Please ask for: Ms Iqraa Malik
Email: iqraa.malik@terraquest.co.uk
Telephone: 01212341390
Our Ref: P/9/21/HH
Your Ref:
Date: 20th January 2021

Application for Planning Permission for Works or Extension to a Dwelling

Development: Single storey rear extension with flat roof together with alterations to existing bay windows to the front of the property.
Location: 9 Kings Drive Pagham PO21 4PY

dwg.title As Built Floor Plan and Roof Plan

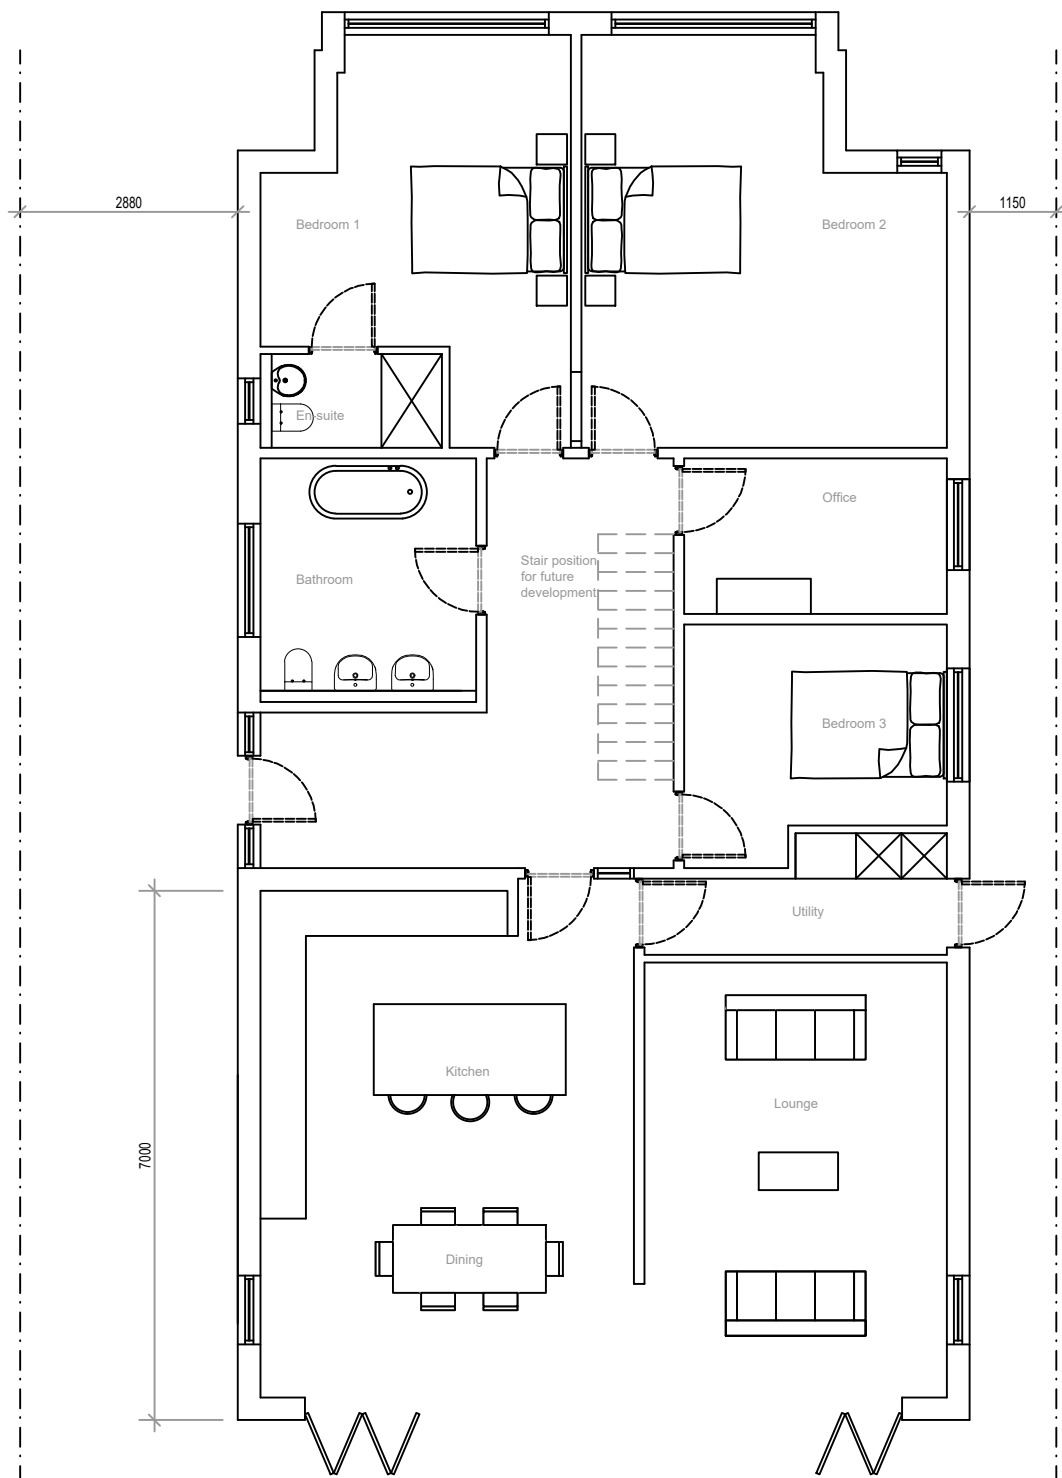
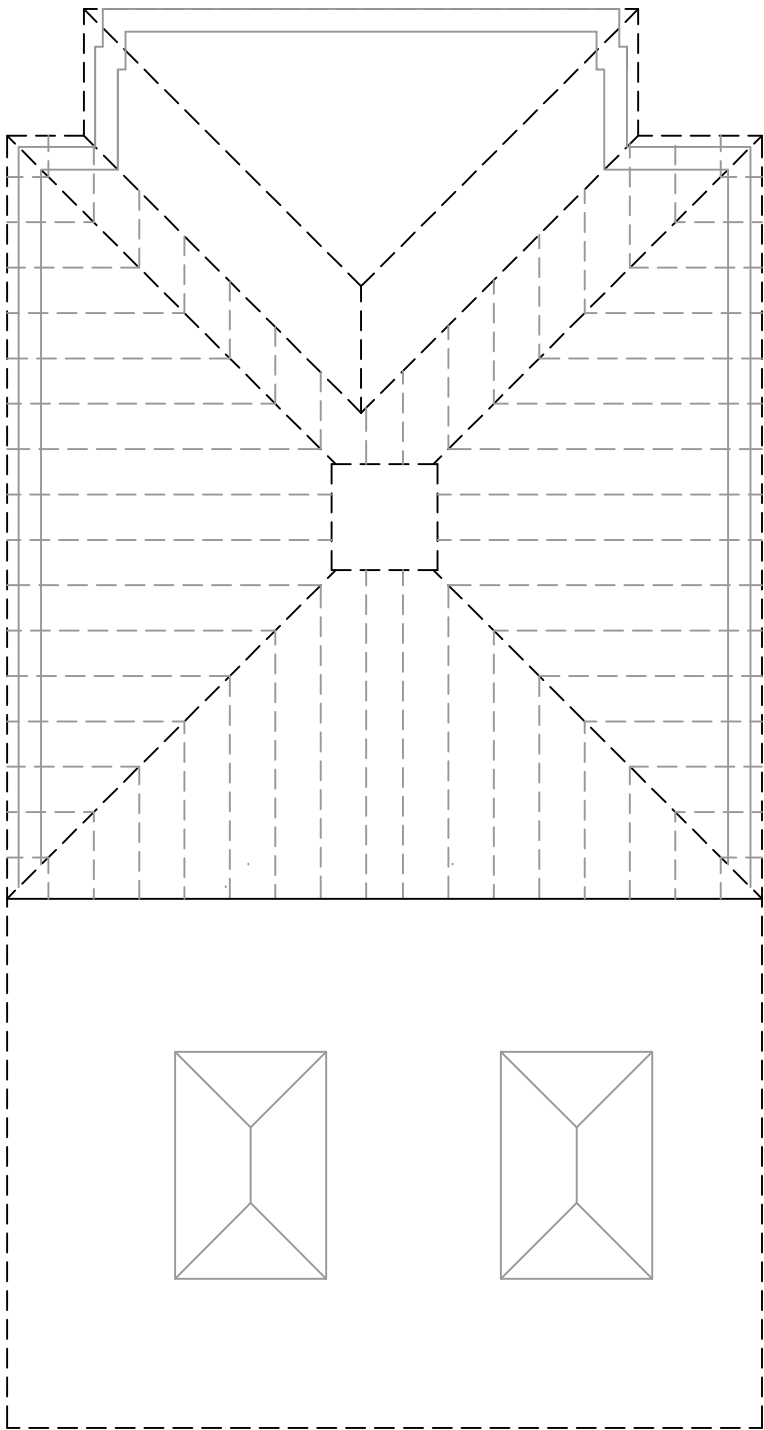
Dimensions: You are required to include dimensions from the proposed extension to all site boundaries.
